**PROJECT: SNOQUALMIE SUMMIT INN  
CDA JOB #6788**

**SUBJECT: AMENDED MASTER PLAN APPROVAL**

RE: Snoqualmie Summit Inn PUD

PROJECT: MASTER PLAN FOR SNOQUALMIE SUMMIT INN SNOQUALMIE PASS, WASHINGTON

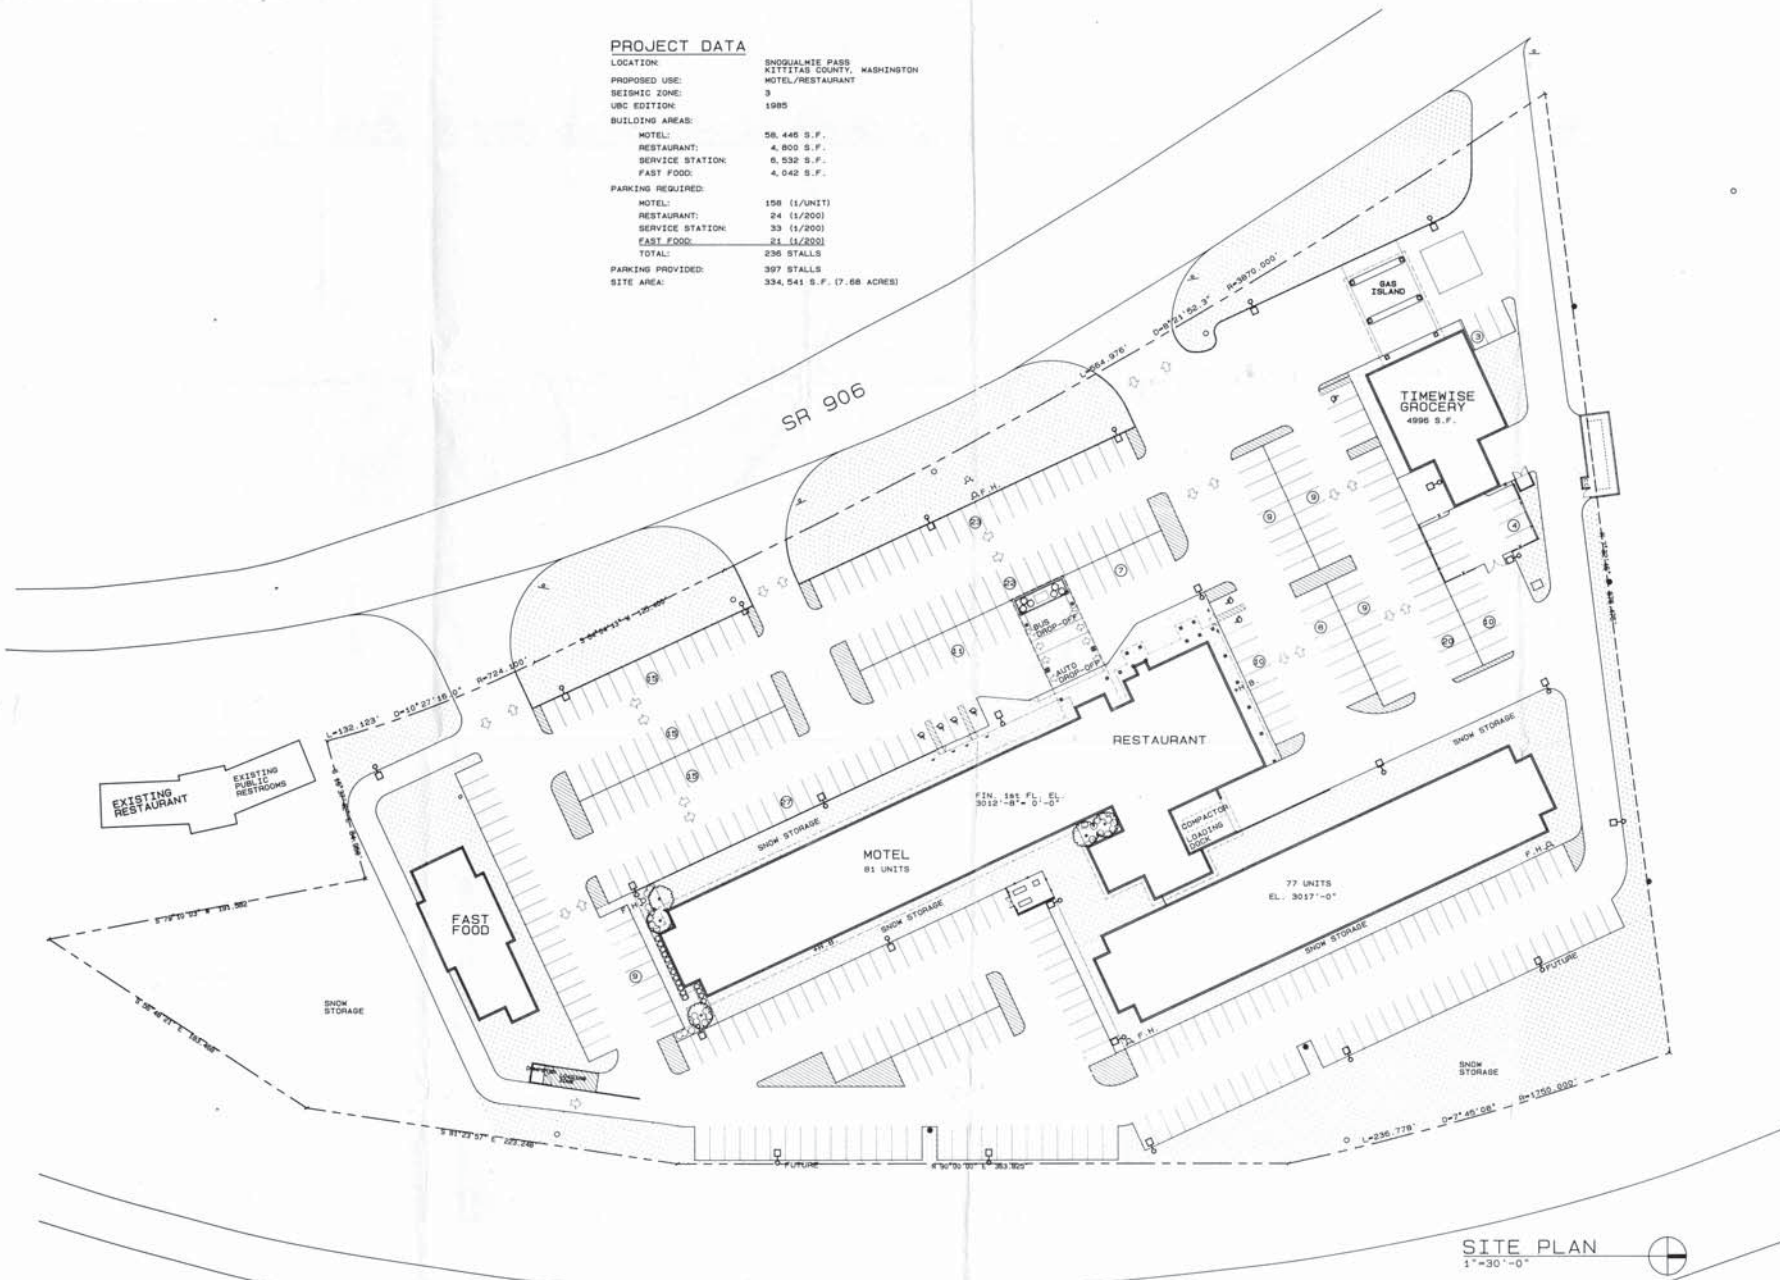
The proposed 30' X 40' addition to the existing restaurant footprint within Snoqualmie Summit Inn, Inc. Planned Unit Development (PUD) is considered an insignificant amendment to the PUD. A formal amendment process will not be required for this alteration. The Master Plan of the PUD was last amended 4/14/89 by former Planning Director Tom Pickerel.

The 1995 addition will result in expanded capacity of 35 occupants for lounge use. Lounge use is considered part of restaurant use. Five parking stalls will be eliminated by the increased building footprint. The overall PUD was required to contain 236 parking stalls, the approved master plan provides for 397 stalls; now 392 stalls.

Permits for improvements regarding the lounge may be issued without further approvals from Kittitas County Planning Division.

PROJECT: MASTERPLAN FOR SNOQUALMIE SUMMIT INN SNOQUALMIE PASS, WASHINGTON

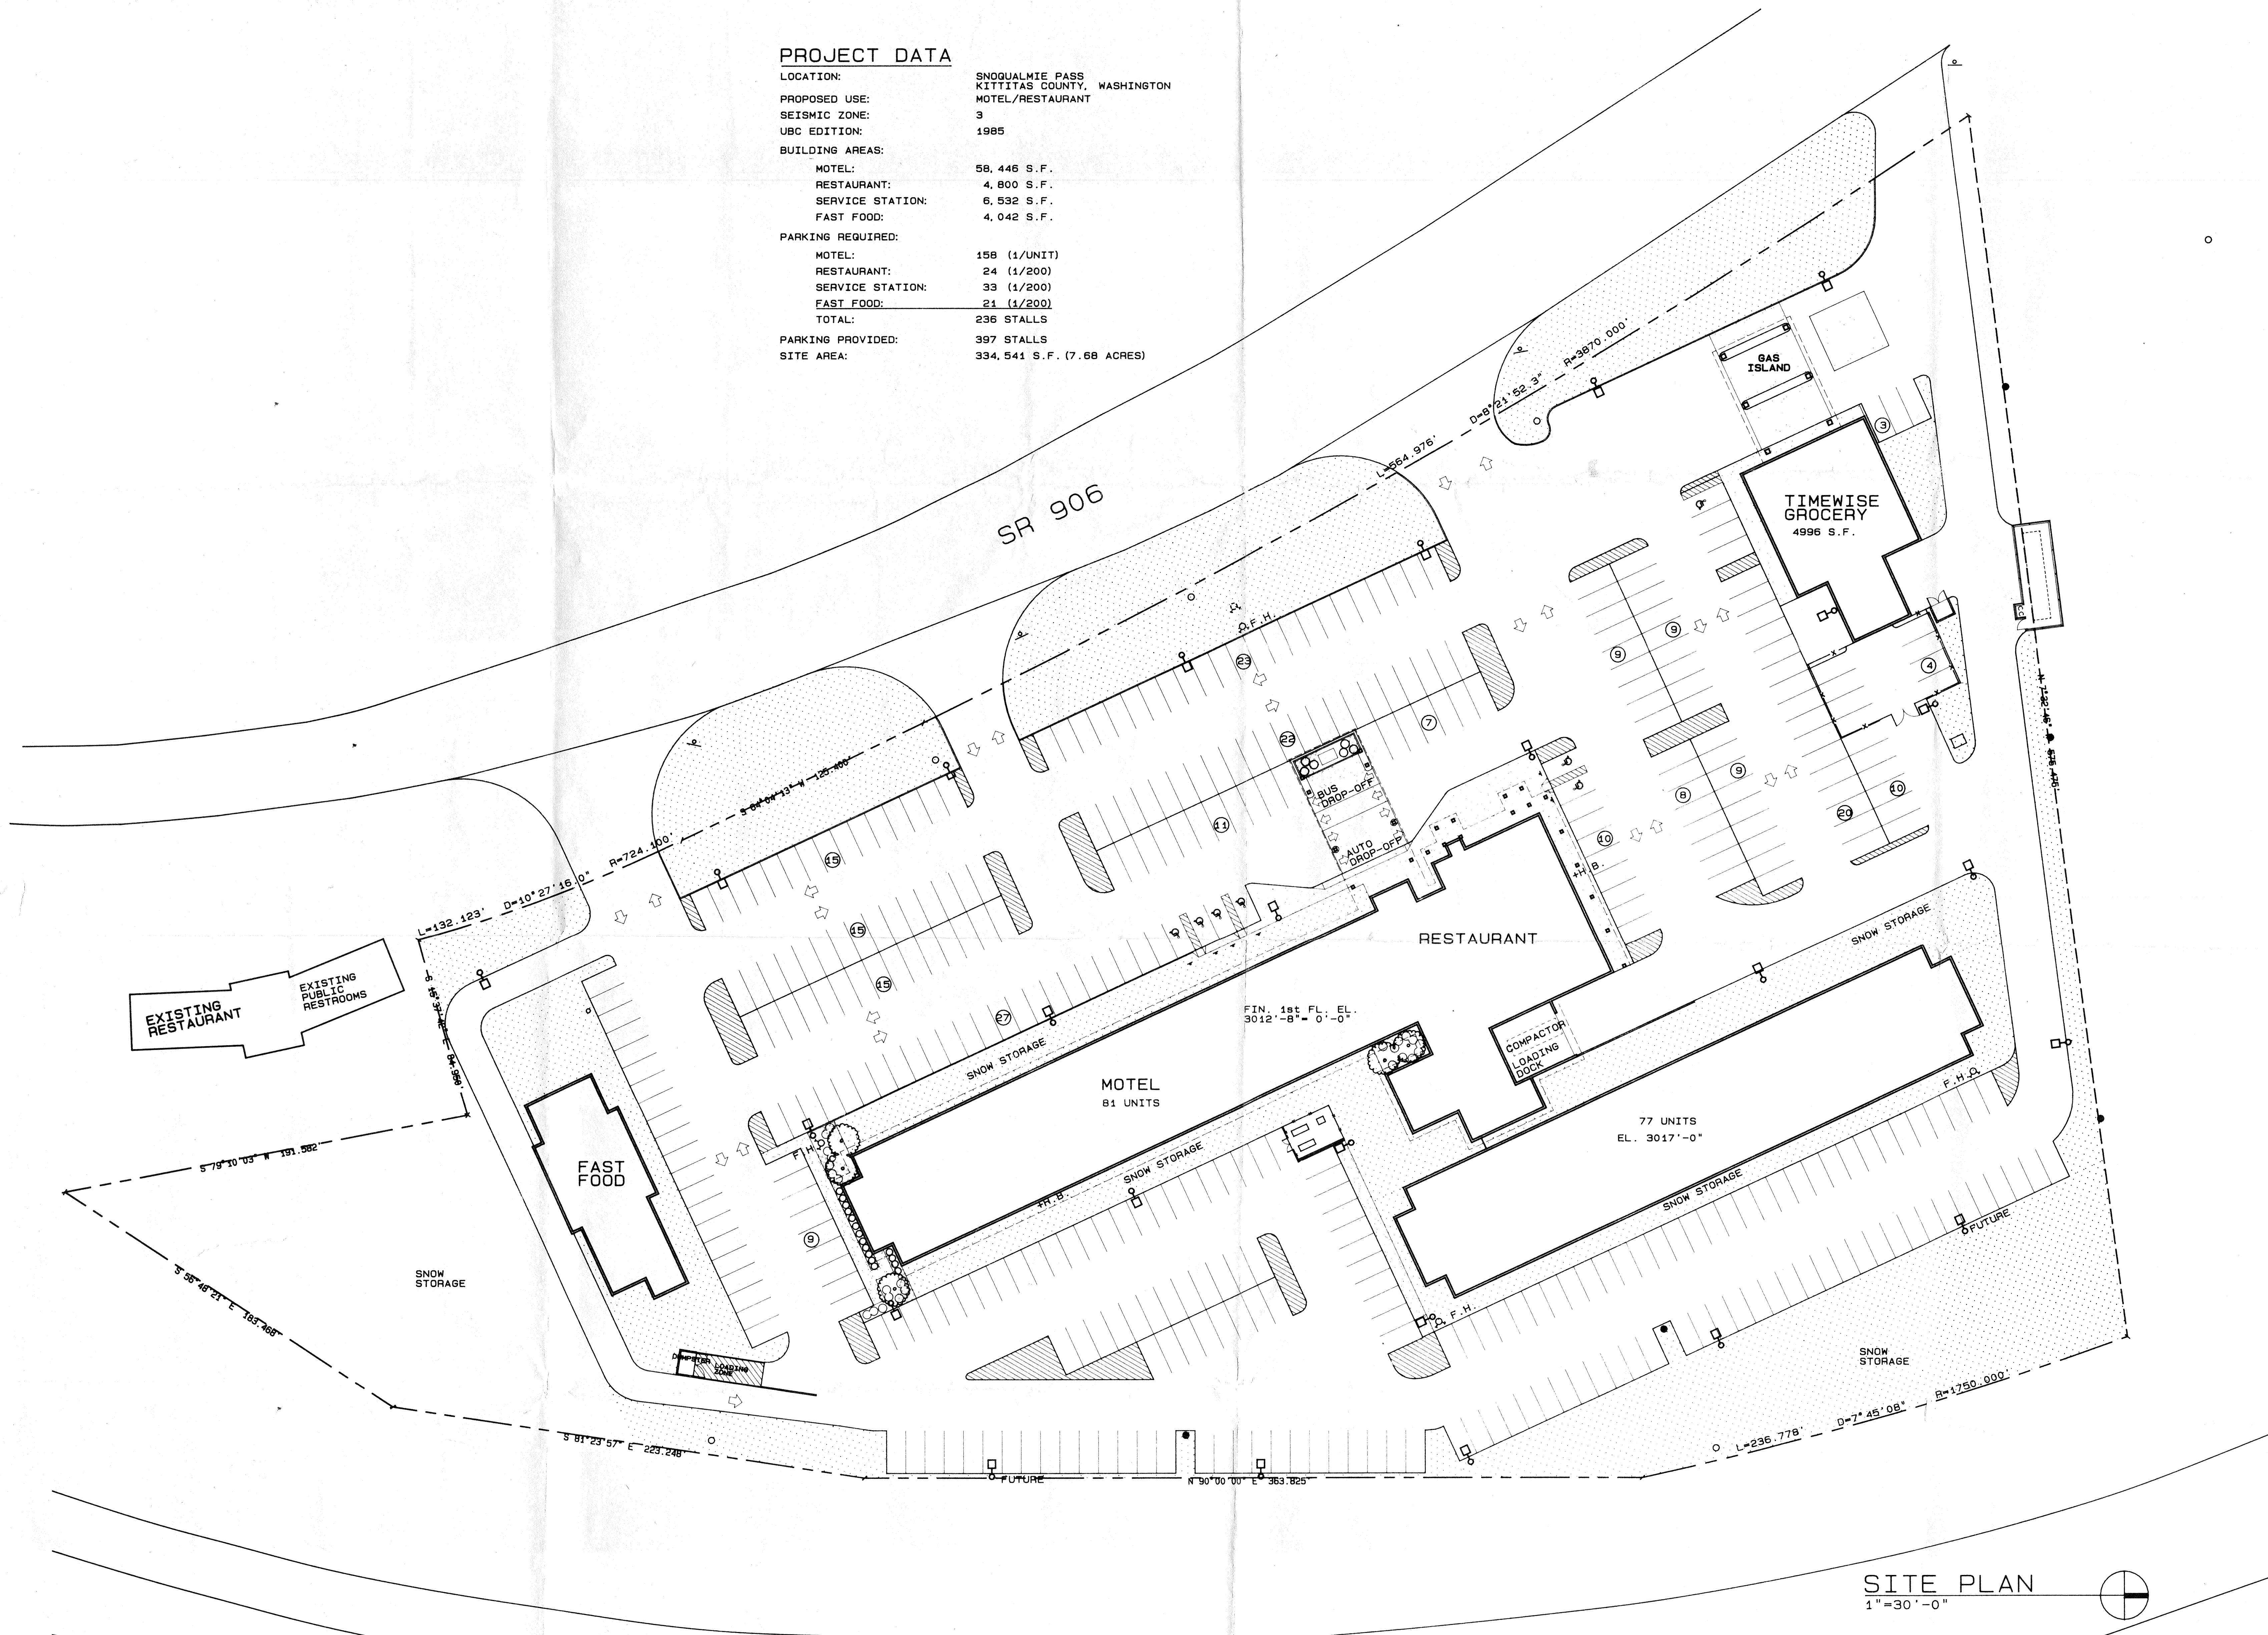
As the revised plan indicates, the changes that have occurred are relocating the building footprint. The restaurant has been incorporated into the motel footprint. The motel will be built in two phases with the motel/restaurant being constructed first along with the gas/grocery store.
